Application No: A/82/20/HH
Site Address: Harcourt West Drive Angmering BN16 4JE
Description of works: Extend domestic single storey garage and single storey enclosure to existing pool.

Thank you for your internet representation made on 16th July 2020 which has been recorded as an objection with the comments as follows:

<table><tr><td>PROJECT HARCOURT West Drive. Angmering Littlehampton. BN16 4JE</td><td colspan="3"></td></tr><tr><td>DRAWING PROPOSED PLAN and ELEVATIONS</td><td colspan="3"></td></tr></table>

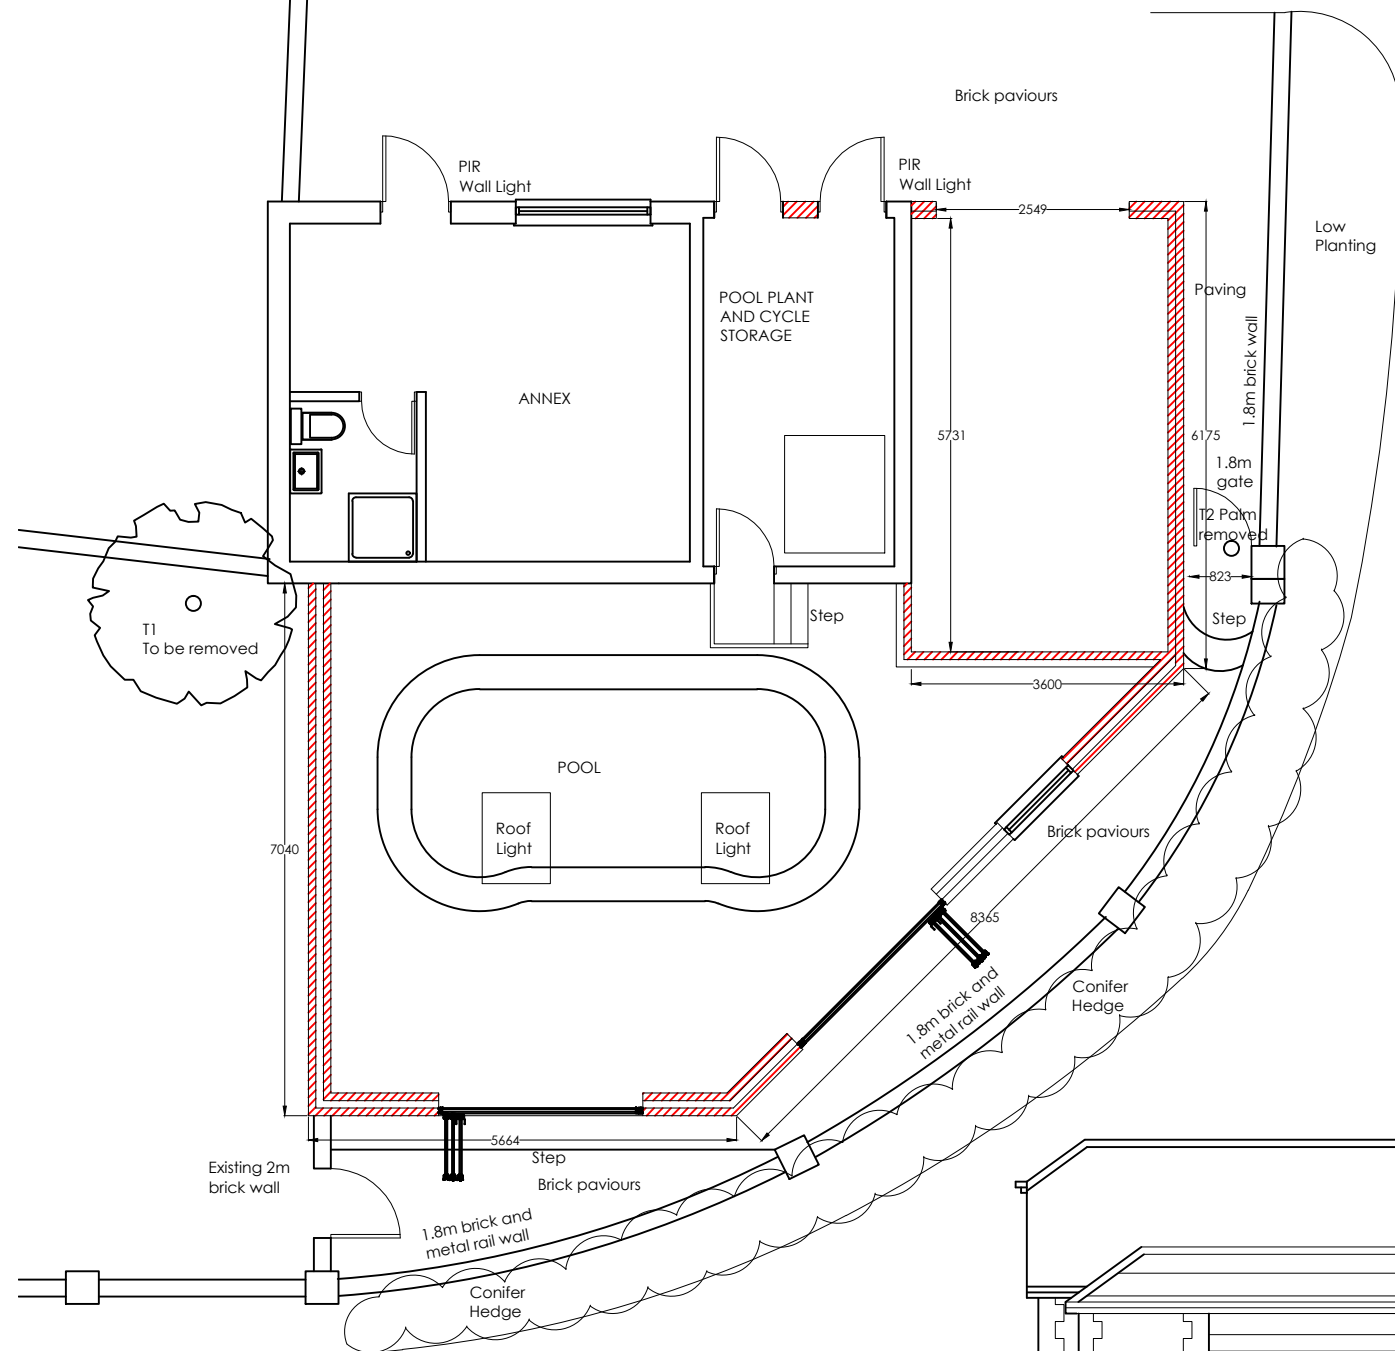
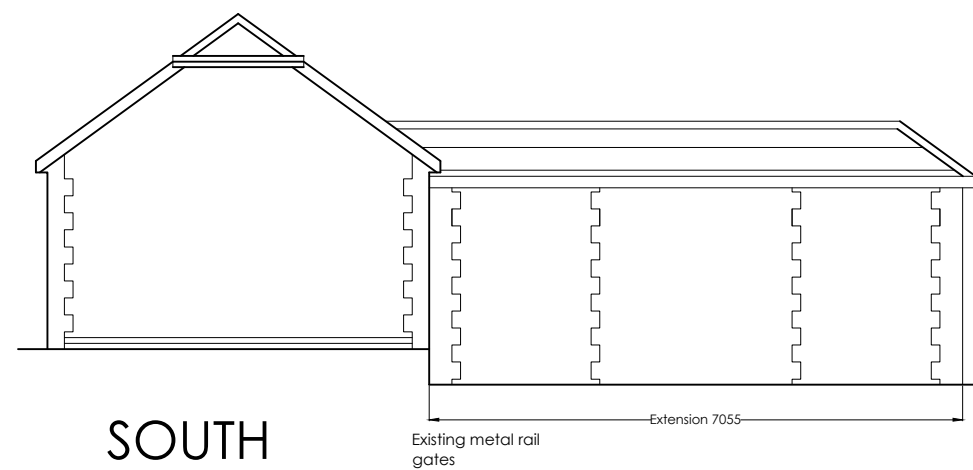
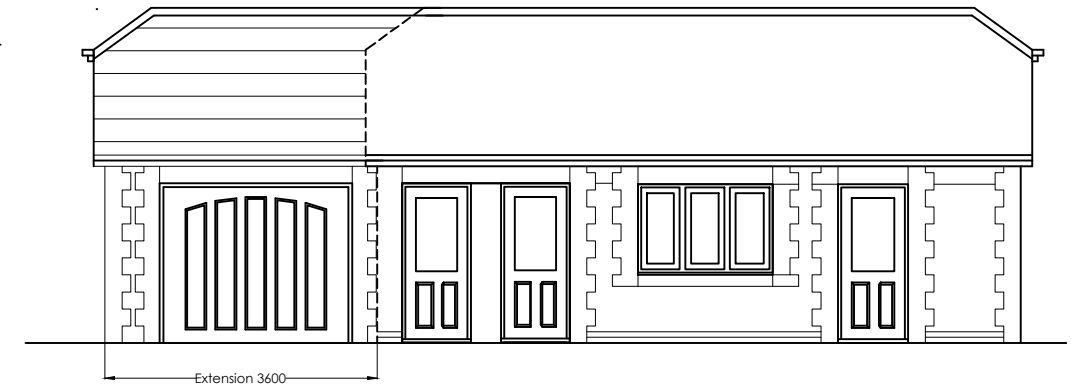
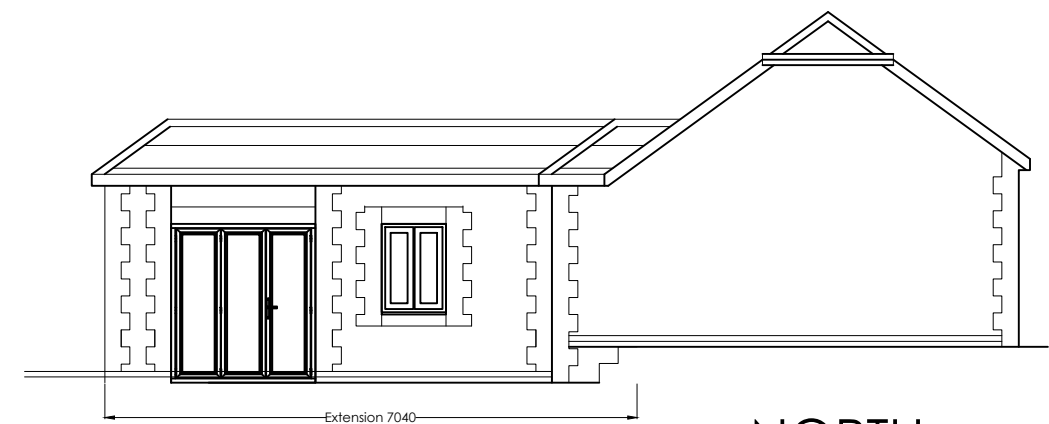
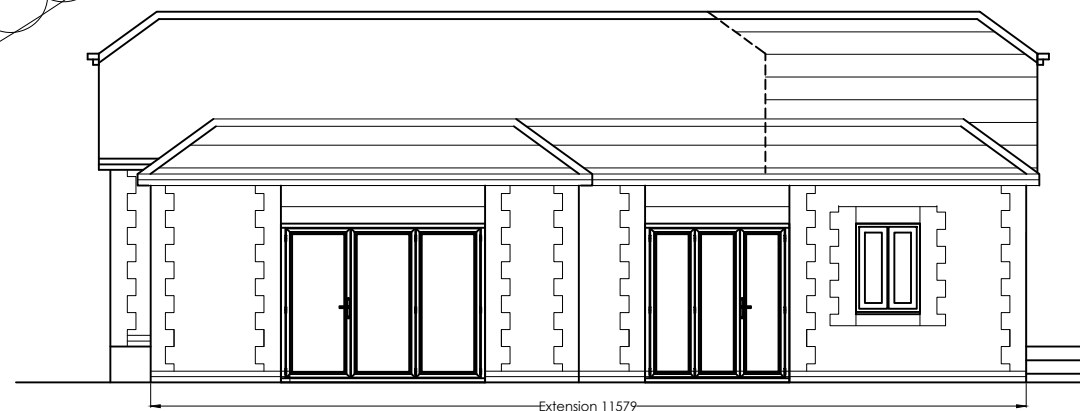
The development makes insufficient allowance for the location, an area characterised by its open spaces. While the proposal benefits from a low wall and iron railings the extension in the pool area is too close to the road and given its size will be overbearing. Destruction of the tree, (T1) which previously was only recommended for height reduction, appears unnecessary and will only emphasize the scale of the building and lack of sympathy with the surroundings.
